Reference: EN010080

**Application by Orsted Hornsea Project Three (UK) Ltd for an Order Granting
Development Consent for the Hornsea Project Three Offshore Wind Farm**

Written Representation

Figure 3.21 Construction Compound Options.

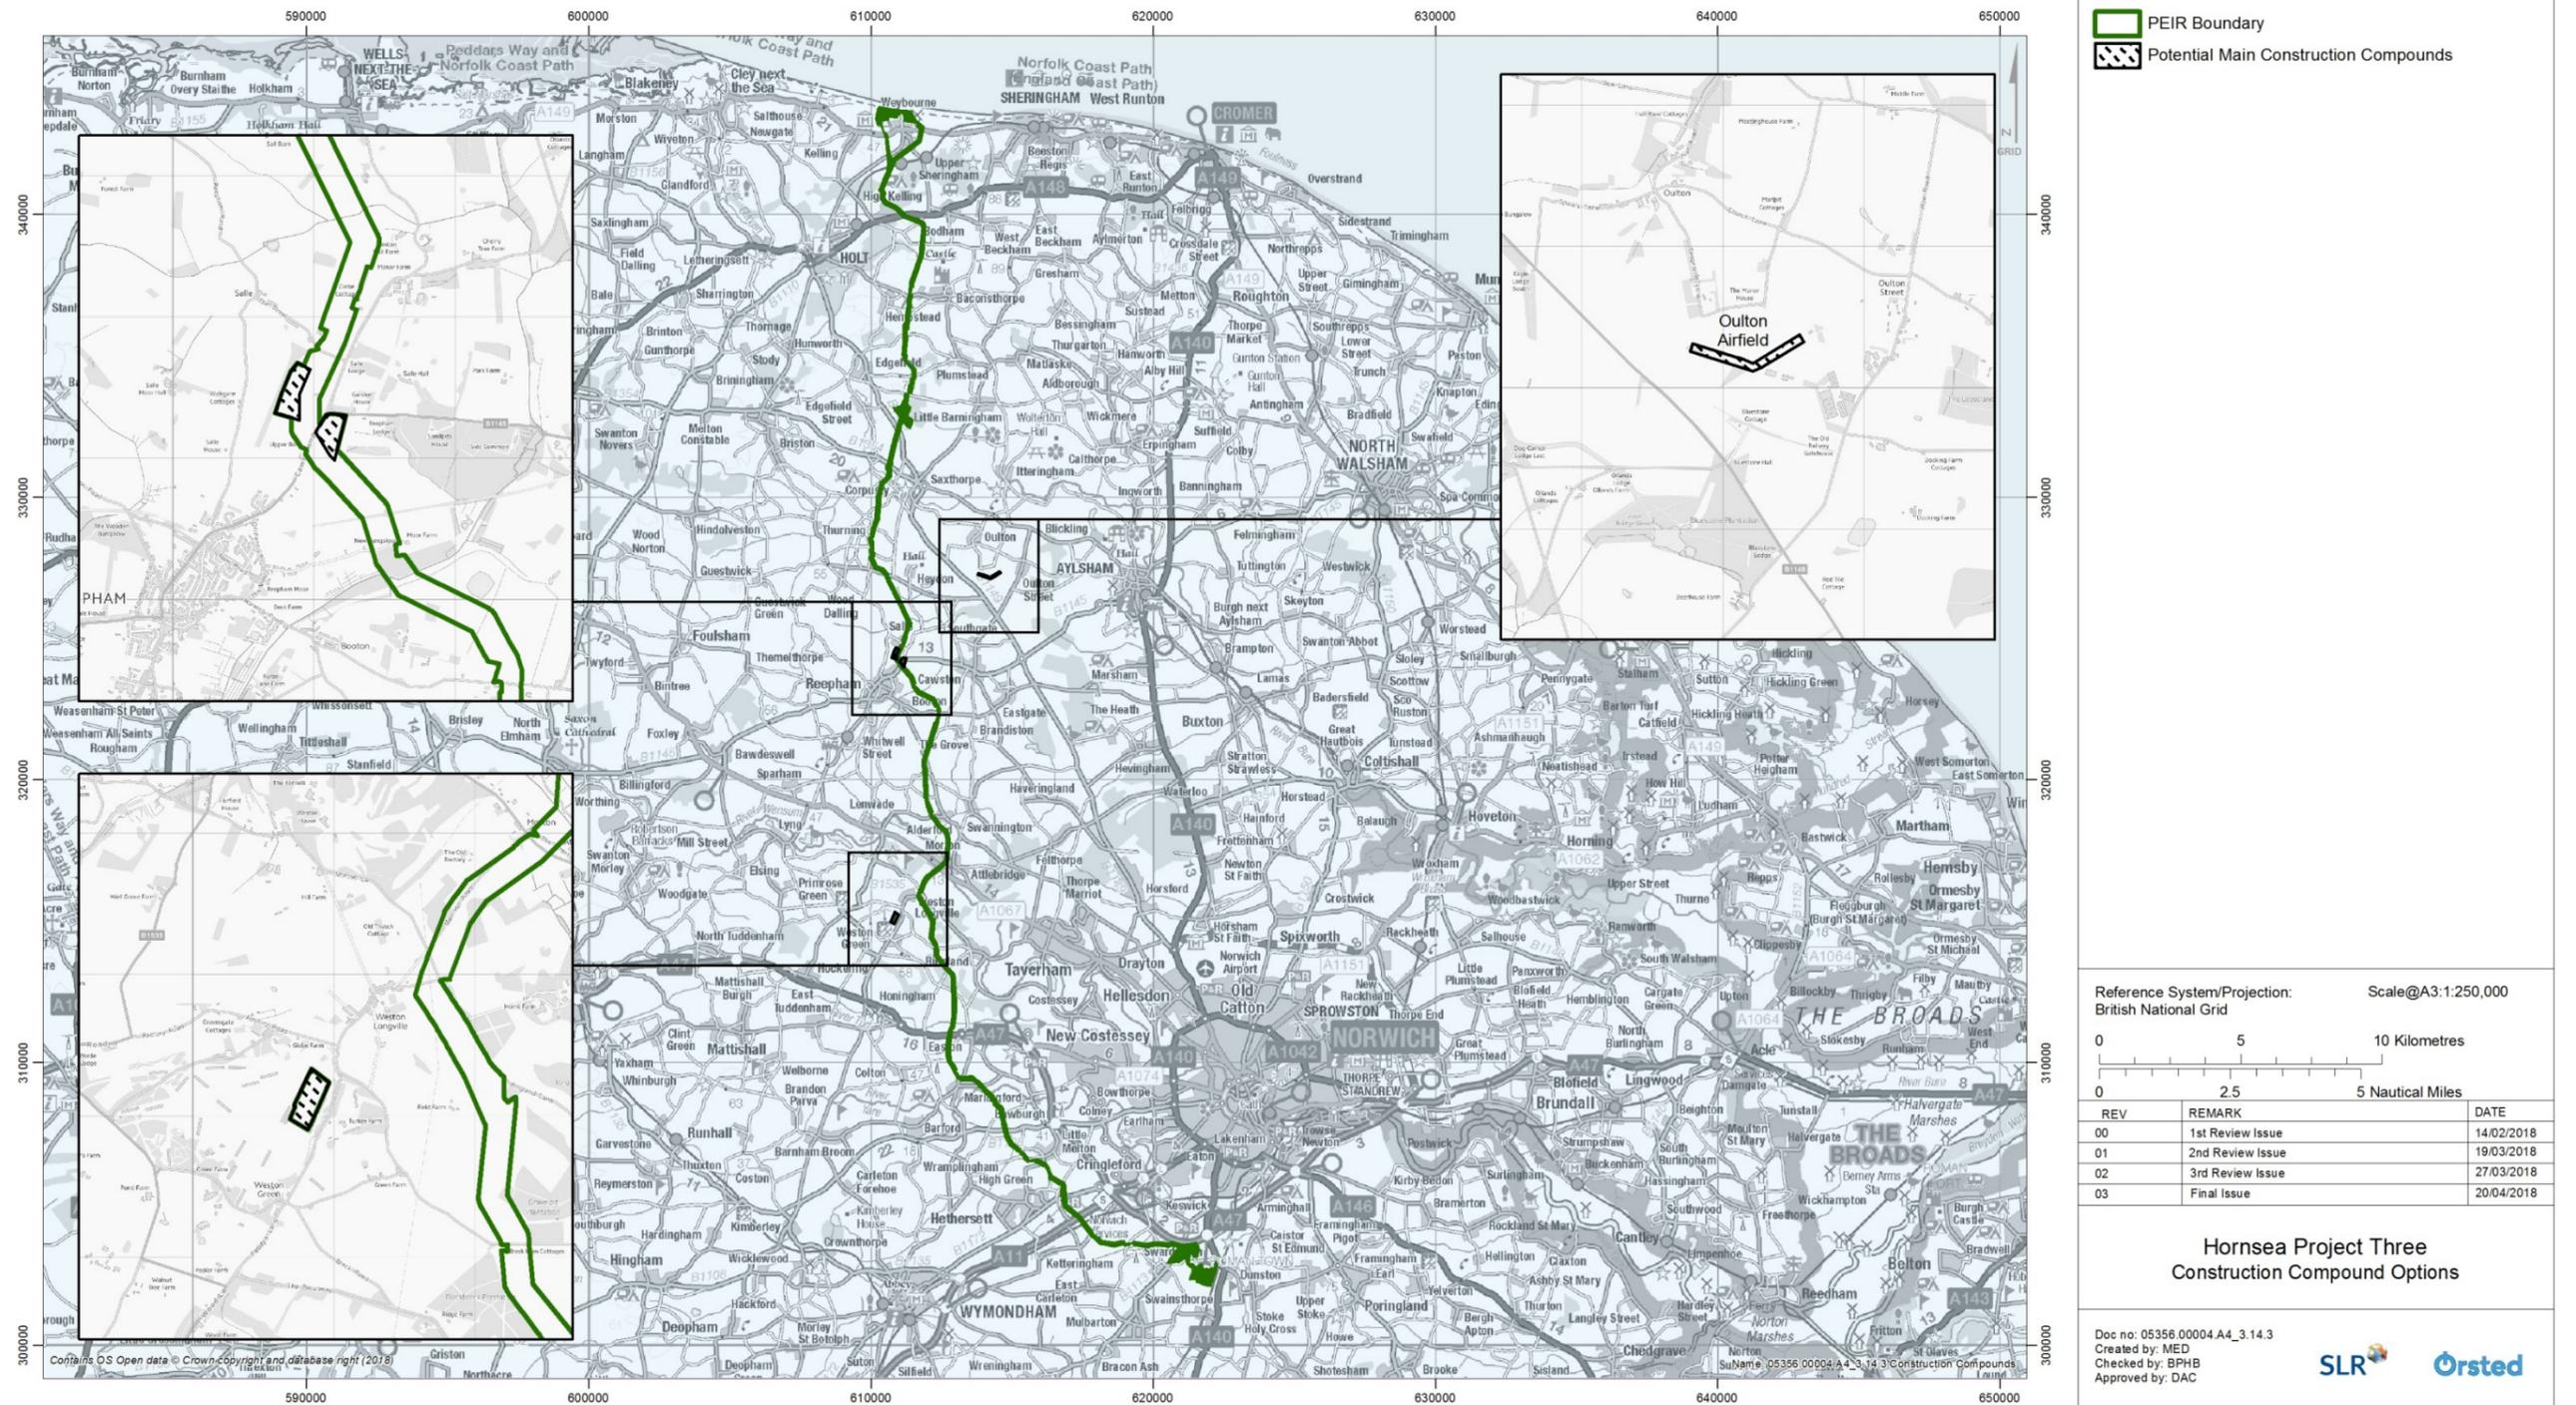
It is noted that three other sites for the construction compound were discounted due to the adequacy of the access for heavy goods vehicles, distance from the strategic road network and absence of hardstandings. The Oulton Airfield location was put forward and chosen as the preferred option following the publication of the Preliminary Environmental Information Report (PEIR). It is stated that the chosen site has direct access from the B1149.

Figure 4.1: Main Construction Compound.

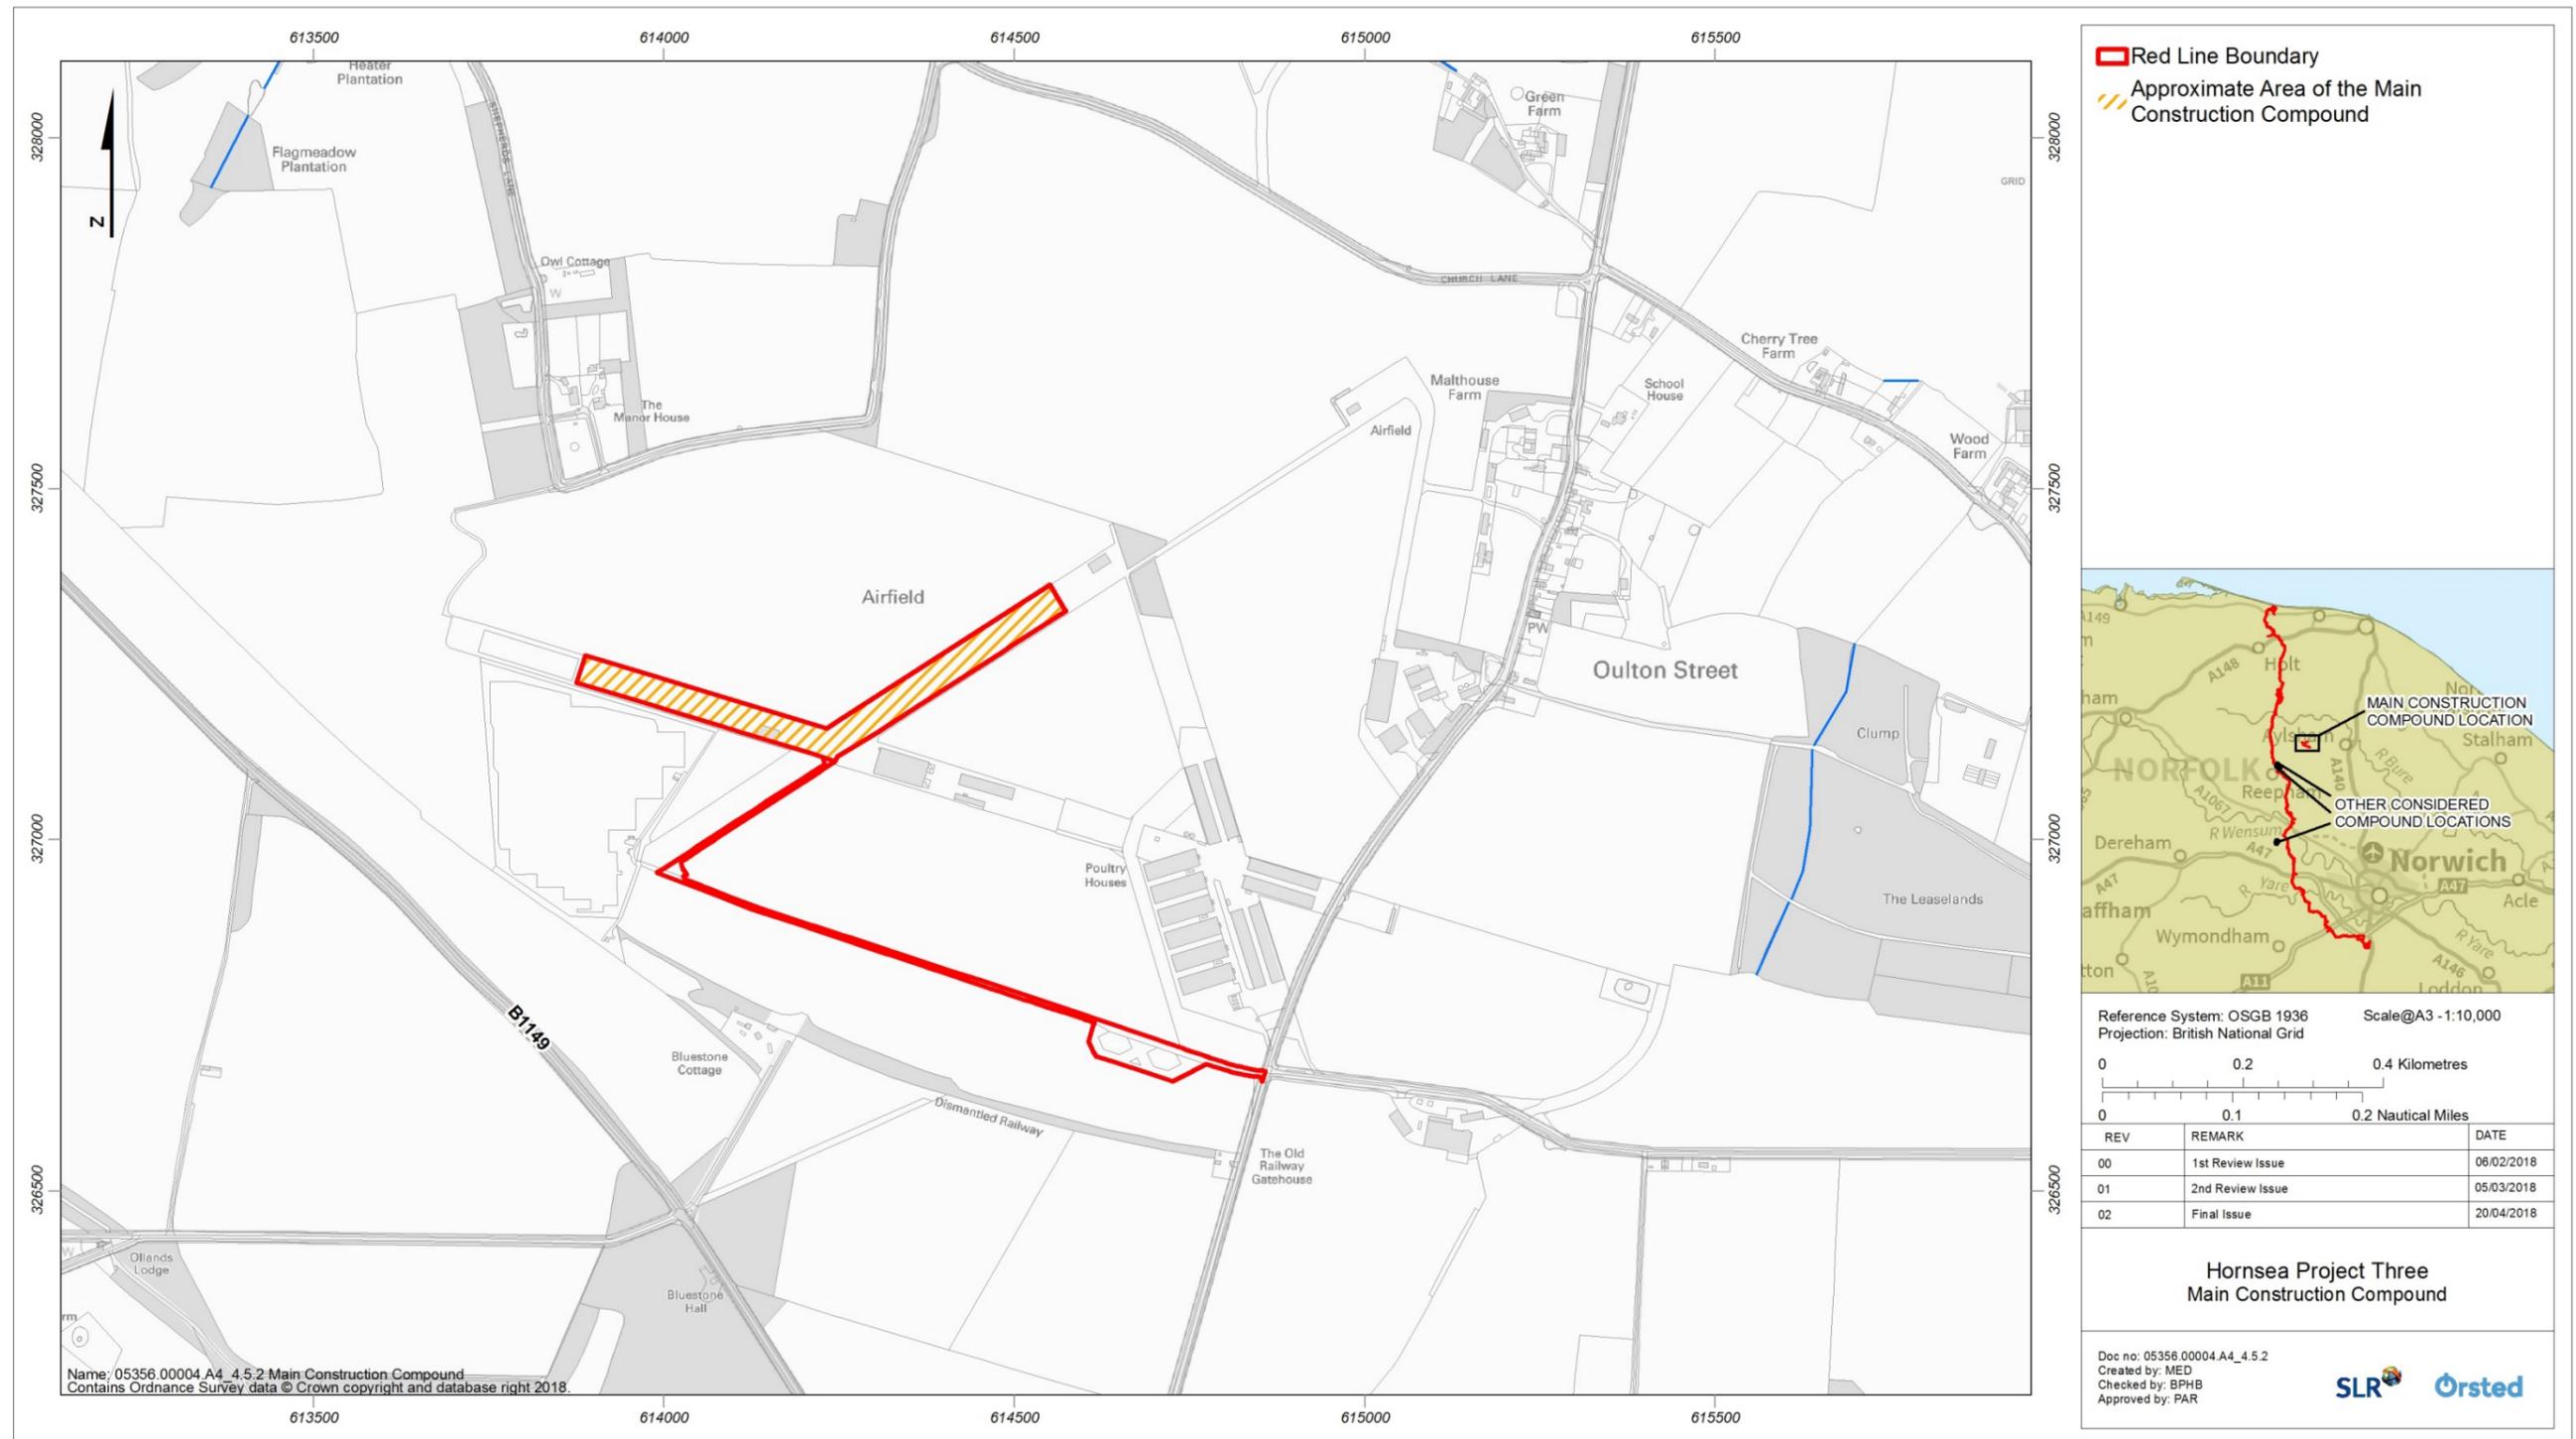
The airfield is located on 'The Street' which is accessed from the B1149, however, this is a rural road and the National Trust questions the appropriateness of this for use by the construction traffic. Information within the application estimates the potential number of vehicle movements at the main compound at Oulton Street, would equate to a peak of 130 daily staff vehicle movements and a peak of 118 daily HGV movements. The applicant also acknowledges that this is a "narrow single carriageway". Furthermore, as indicated in the submission, it is located approximately 3.5 km to the east of the main ECR.

The applicant acknowledges that there are concerns regarding the use of this site specifically in terms of access but considers that these can be overcome through suitable traffic management measures. Details of such measures have not been included at this stage. It is stated that these measures will be developed as part of the subsequent Construction Traffic Management Plans (CTMPs) secured prior to the commencement of works and activities at the main compound, when the scope of the use of the main construction compound by the principal contractor is known. It is also stated that the traffic management measures may involve diversion routes. The National Trust is concerned about the impacts that the level of traffic using this rural road and the impacts the traffic

Should this location be considered acceptable as a construction compound it is important that any construction traffic accessing this compound is aware that it should be accessed from the B1149 and not from a northerly direction where it would pass through the village and could adversely impact upon amenities.

Unfortunately the significance and character of the airfield, its historic relationship to the village and the Blickling estate and thus the contribution it makes to the setting of the Blickling Conservation Area have not been acknowledged within the application. The operation of this site as the main compound with the level of facilities and transport movements outlined above should be considered in the context of the historic environment but is absent from any assessment in Volume 3, Chapter 5 (Historic Environment) of the Environmental Statement.

There is reference to the comments of Norfolk County Council which states The extended accesses area includes the only surviving aircraft dispersal area associated with former Royal Air Force Oulton Airfield. The surviving Second World War concrete hard-standings should be retained and their form not altered. The same is true of the section of former runway intended for storage. The response to this by the applicant was that 'The comment is noted'. There is no evidence to suggest that the applicant has carried out a thorough appraisal to ensure any harm caused to the heritage asset of the airfield is minimised.

The National Trust is supportive of the need for renewable energy but in this particular case, we are concerned that the site chosen for the compound would cause harm to the undesignated heritage asset of the airfield and erode the ability to appreciate the contribution of the airfield to the historic environment, including its link with Blickling Hall. The proposed use of the site and scale of the operation would neither preserve nor enhance the character of designated Conservation Area. Furthermore, concern is raised that the B1149 is not capable of accommodating the transport movements proposed without an adverse impact upon other users of this road and the character of the area.
